North Byron Parklands Development Application Wastewater review

April 2018

GHD | Report for Department of the Environment - North Byron Parklands Development Application, 2316318 | i

Drawn:	Reviewed:	Approved:	Date:	Scale: 1:6,000 Approx @ A3	
HM	SD	SD	13/11/17	Job No: 1912	Sheet: 1 of 1
All units in m unless otherwise specified				Drawing No: Figure 3	Revision No: 3

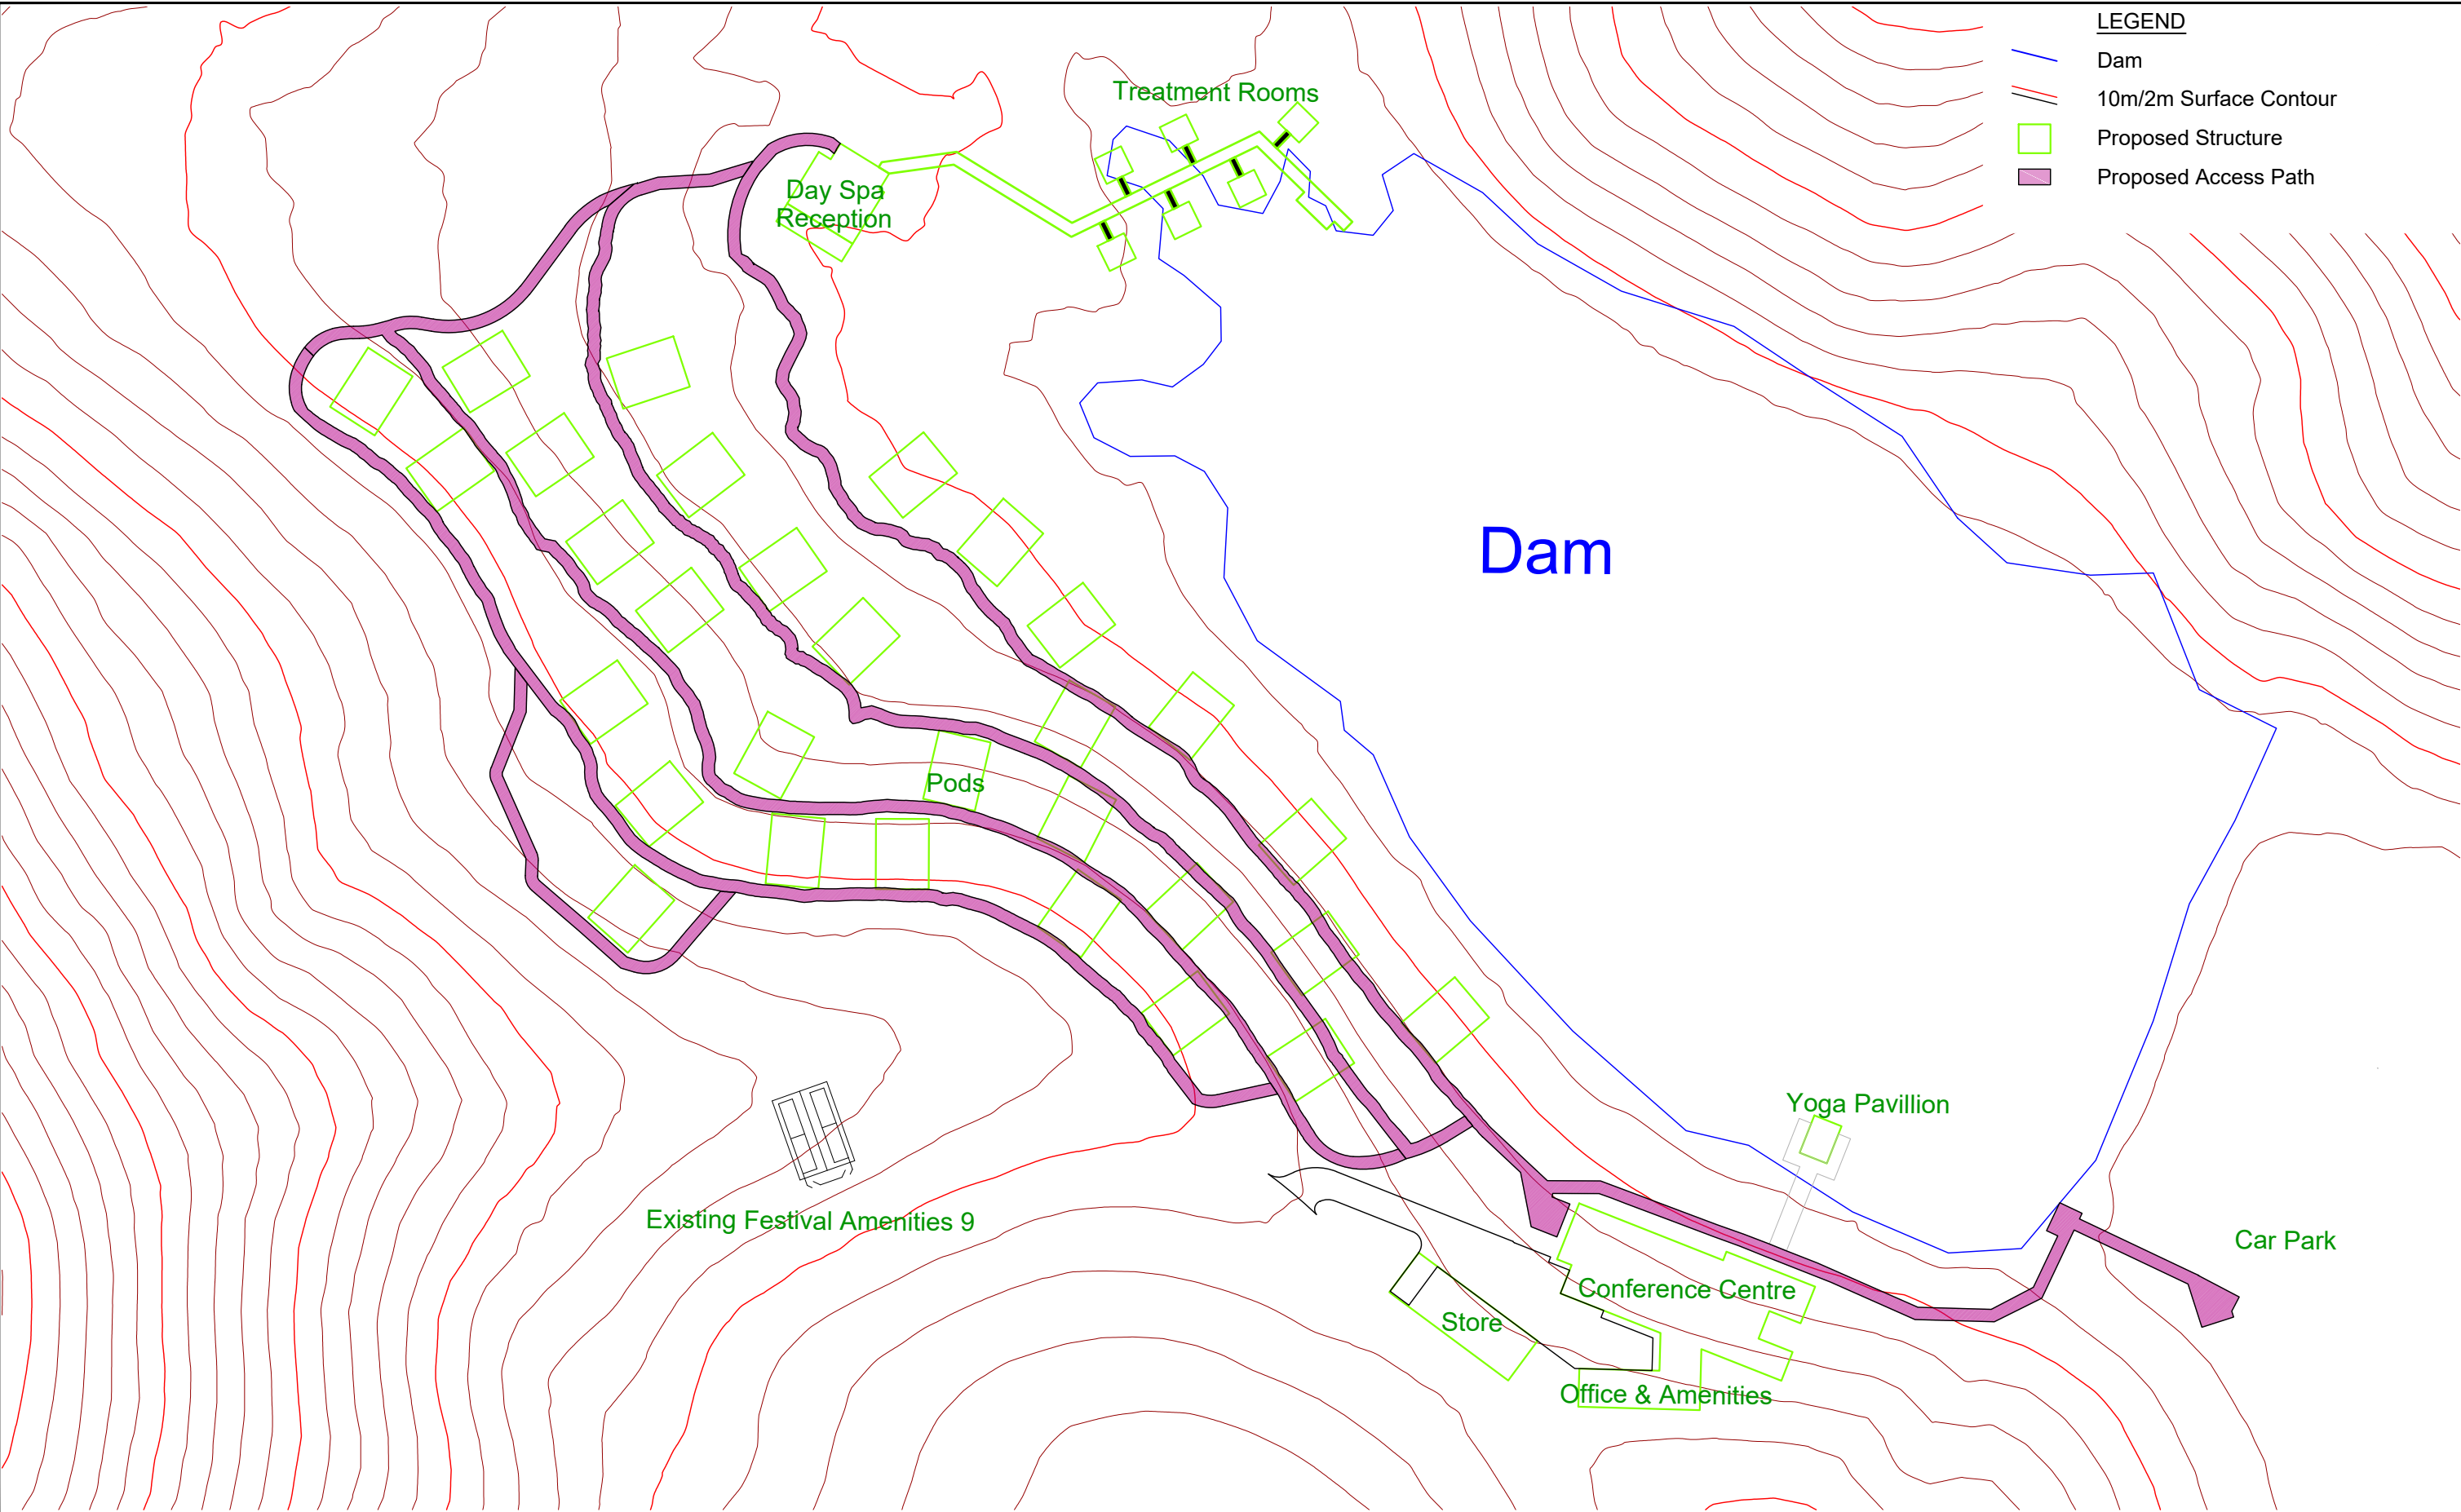
The suggested irrigation value (treated effluent volume) is considered to be very low and much lower than standard volumes adopted for wastewater generation. GHD consequently has two significant concerns – there is an error in volume calculation and consequently the irrigation area required is likely to be much greater than nominated and irrigation of flood prone land using (treated) wastewater is not acceptable due to high contamination risk on- and off-site.
